PORTLAND MAINE

May 24, 2012

RE: 417 Auburn Street (called parcel C) -382-A-009
12 Kenneth Street (called parcel B) – 382-A-5 & 6
22 Kenneth Street (called parcel A) – 382-A-7 & 8

PRELIMINARY PLAN

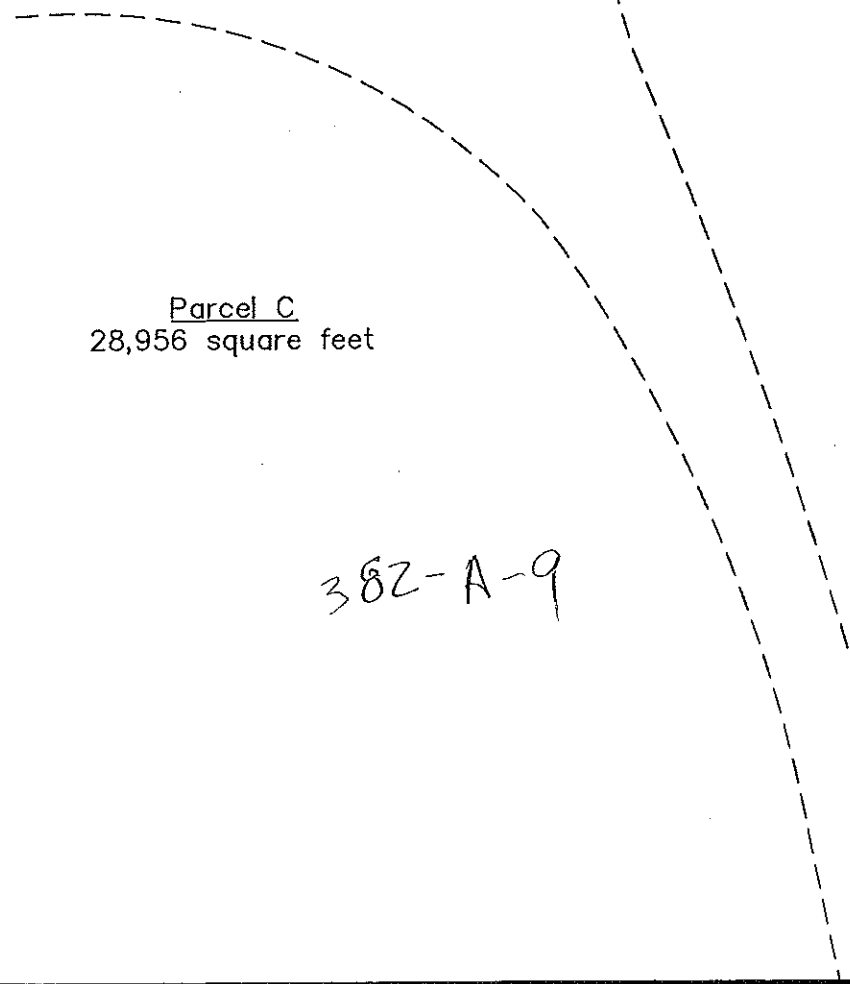
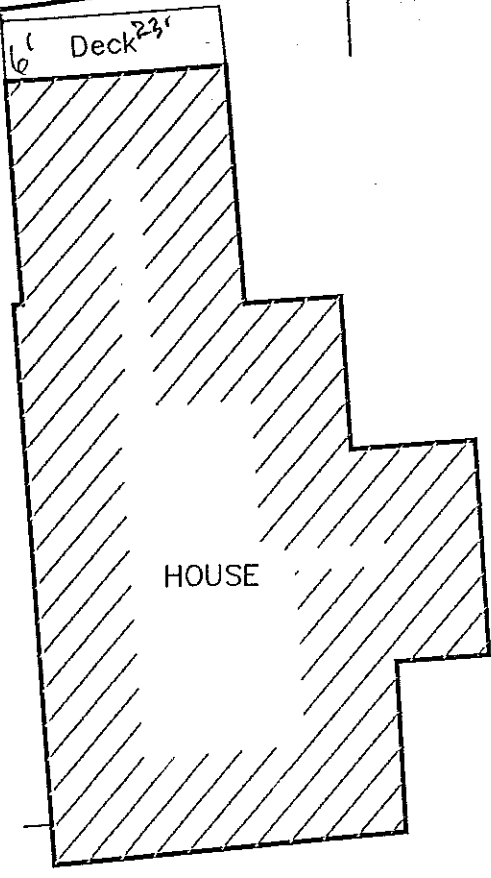
417 Auburn Street: Parcel C is shown to be 28,956 square feet in land area which is well over the R-3 minimum lot size of 6,500 square feet. The minimum street frontage and minimum lot width of the R-3 zone are being met. The building has existed prior to the basis of the City's current zoning ordinance of 1957. The legal use of the building is a single family with an accessory dwelling unit. The Zoning Board of Appeals approved a conditional use for the accessory dwelling unit on 12/06/2007. Please note that all conditions must be maintained during the existence of the accessory dwelling unit, such as the owner residing on site in one of the approved units.

The survey shows the existence of a 6' x 23' deck on the rear of the building. Inspection Services never received a building permit for this deck. Using the Assessor's records, it appears the deck was erected between 1988 and 1990. Again, this office does not have any evidence of a required building permit. This is important because the deck has been built to within approximately 1 foot of the rear property line. The rear deck is in violation of the required rear setback in the R-3 residential zone. It is my understanding that parcel A is to be conveyed to a separate owner from parcel C. Under zoning, the deck creates a violation of the zoning ordinance. If the deck were to be removed, the violation of the zoning ordinance would be eliminated.

12 Kenneth Street: The submitted survey shows a 5.01 foot strip of land that extends from parcel B along Kenneth Street and ends at Clayton Street. The 5.01 foot of land is proposed to part of parcel B. Parcel B is shown to be 11,297 square foot in land area which is well over the R-3 minimum required land area of 6,500 square foot. The R-3 zone minimum requirement for street frontage and lot width are being met. The

proposed 5.01 foot strip is not in violation of the zoning ordinance. The proposed 5.01 foot strip does not require a subdivision review. It may be possible to position the 5.01 foot strip of land at the opposite side of the lot along the common property line of parcel A and parcel C as long as all R-3 zone requirements are met. It is not my role to design or recommend any lot configuration. My role is to be sure that the zoning ordinance is being met and any proposal is not in violation of the zoning ordinance.

22 Kenneth Street: Parcel A as shown on the submitted survey is shown to be 11,045 square foot in land area which is well over the R-3 minimum land area requirement of 6,500 square foot. It is being shown as having more than the minimum street frontage of 50 feet. It is being shown as having more than the minimum R-3 lot width requirement of 65 feet.
